# **APPLICANT'S RESPONSES TO RELEVANT REPRESENTATIONS AND ADDITIONAL SUBMISSIONS**

## **Drax Bioenergy with Carbon Capture and Storage**

**Document Reference Number: 8.3**

**PINS Reference: EN010120**

DRAWING TITLE
 FIGURE 18.1:
 SHORT LIST OF 'OTHER DEVELOPMENTS'
 CONSIDERED WITHIN THE CUMULATIVE
 IMPACTS ASSESSMENT
 SHEET OF 1 OF 7

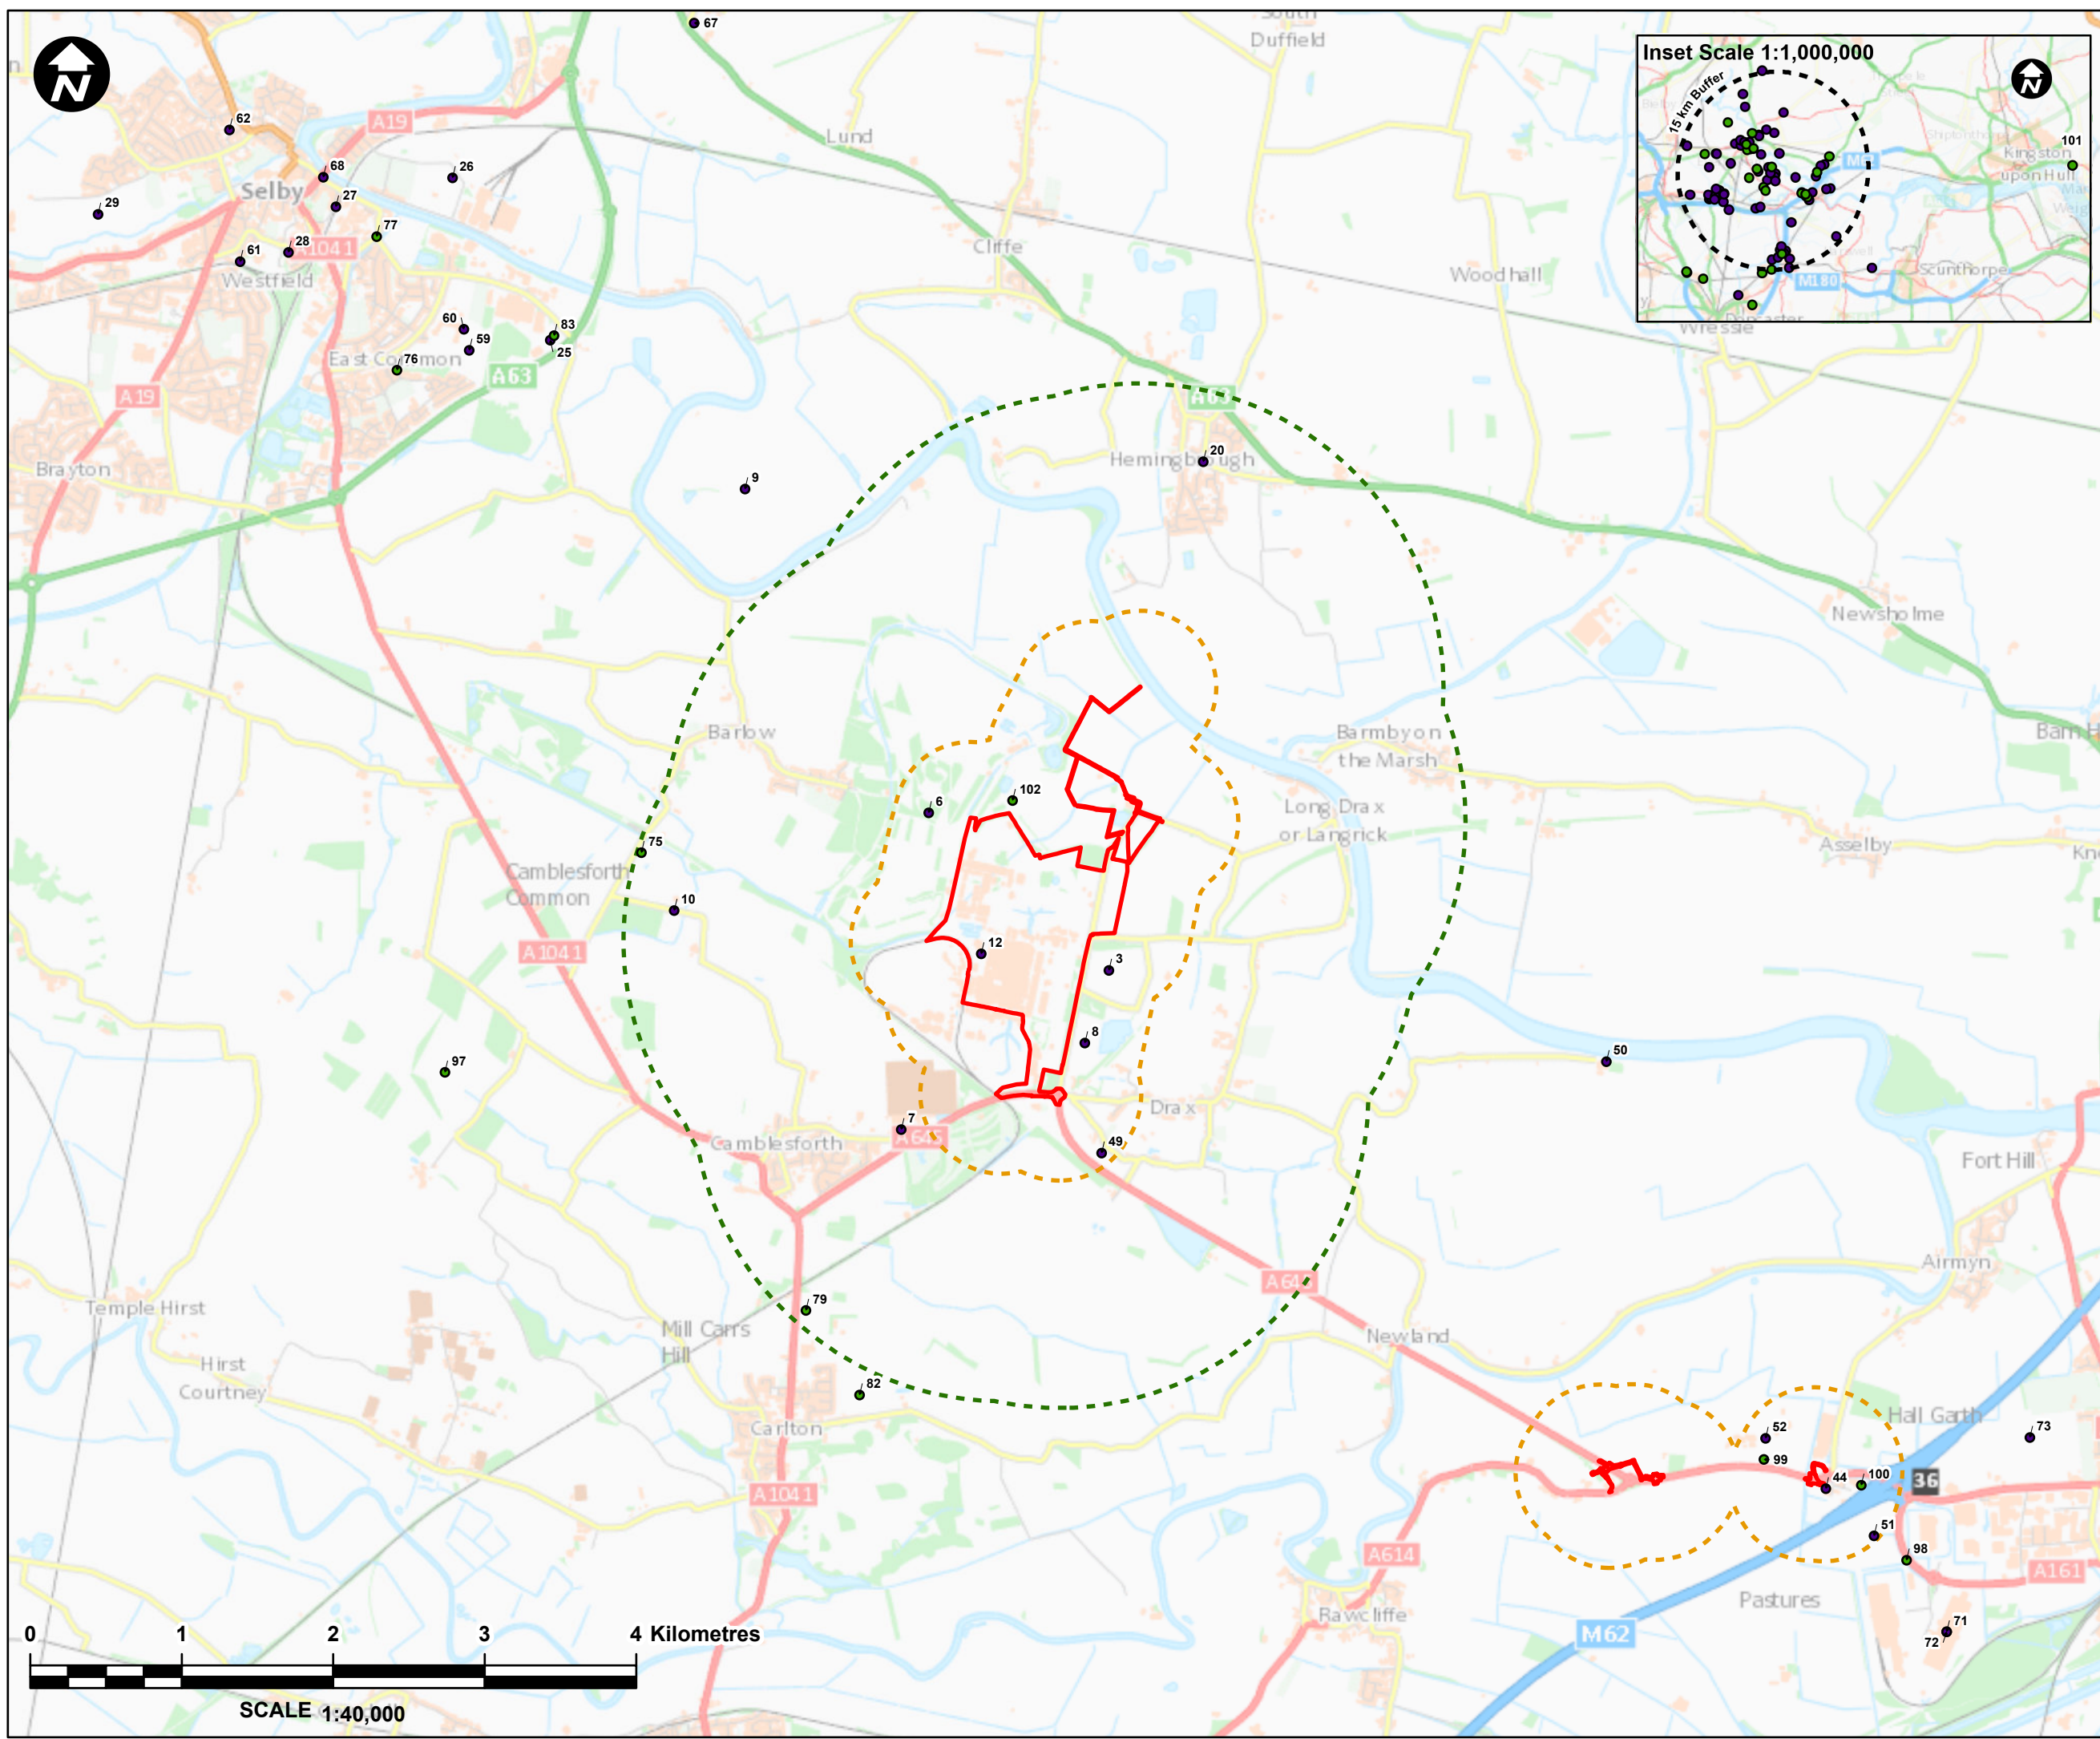
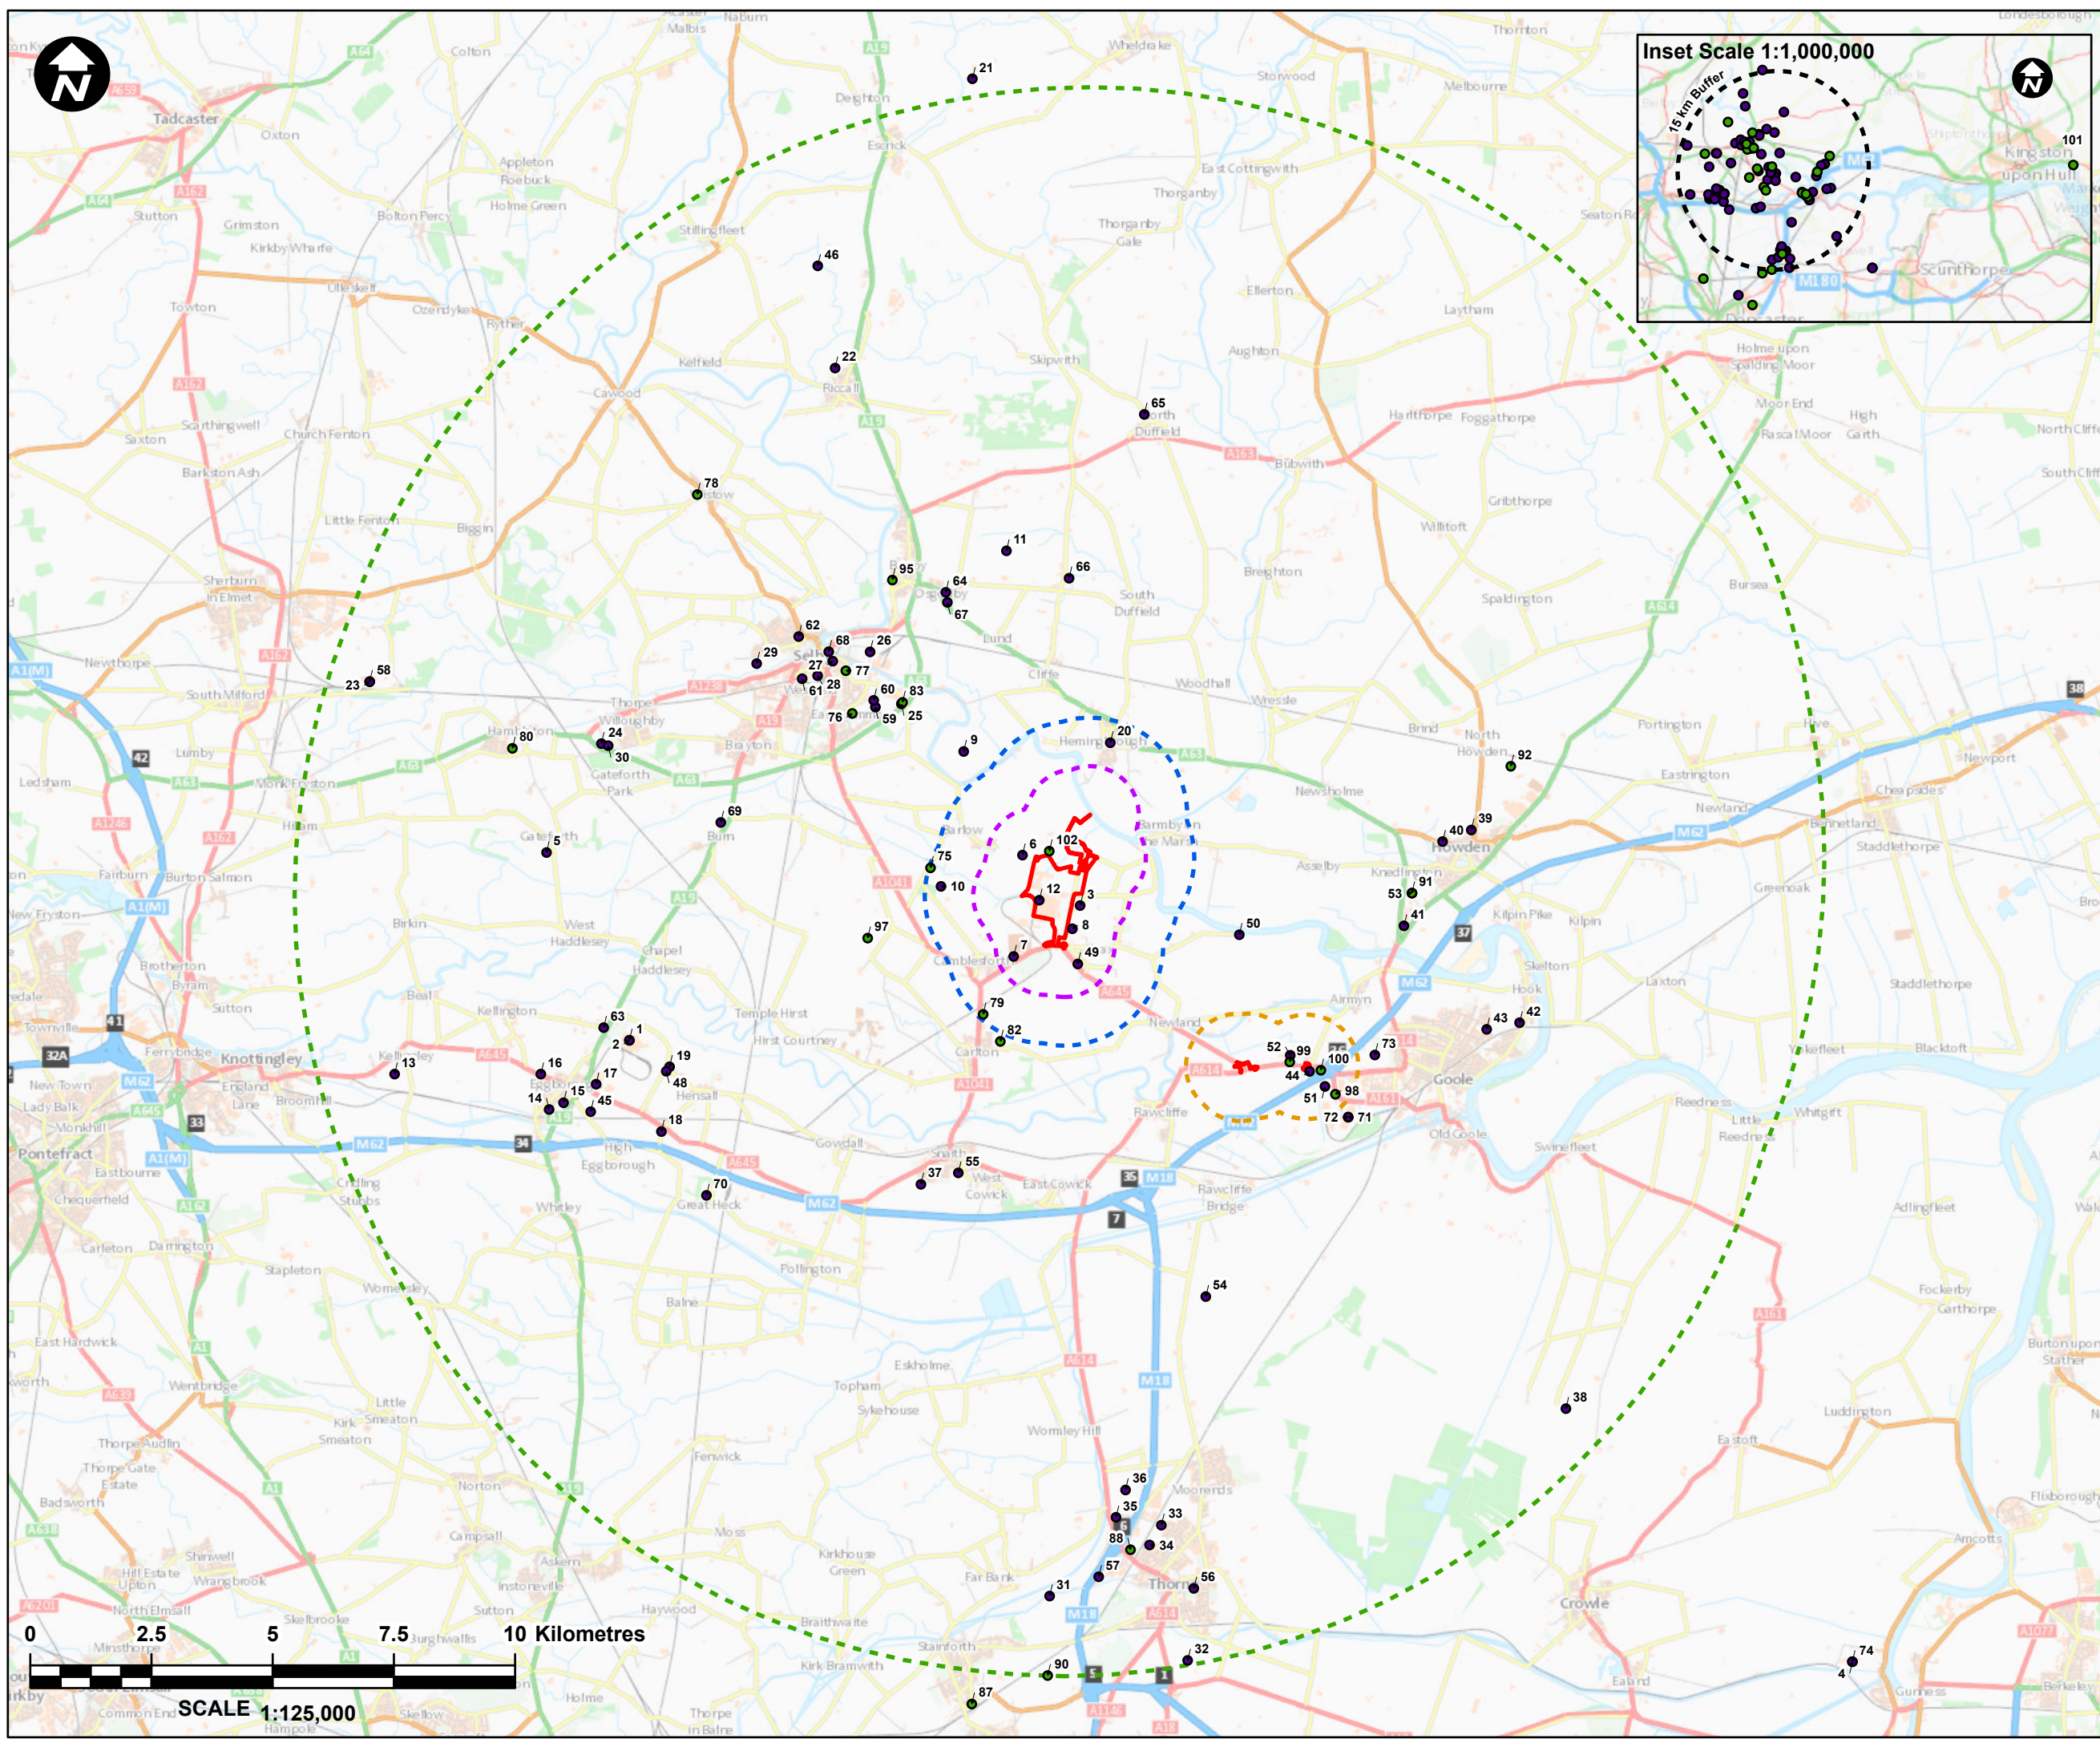
Response Ref.	Relevant Representation Comment	Applicant's Response
2.12. Cumulative	It has been noted that 6.3.18.2 Environmental Statement - Volume 3 - Appendix 18.2 'Short List of Other Developments' only contains 46 schemes, while the Environmental Statement refers to 76 schemes. It is understood that the applicant is aware of this issue and is looking to issue a corrected version for consideration.	This comment is noted and it is confirmed that the formatting error has been amended and a new version was issued to NYCC/SDC and other consultees on 1 September 2022. The updated document was reissued to PINS on 7 October 2022 (AS-013).
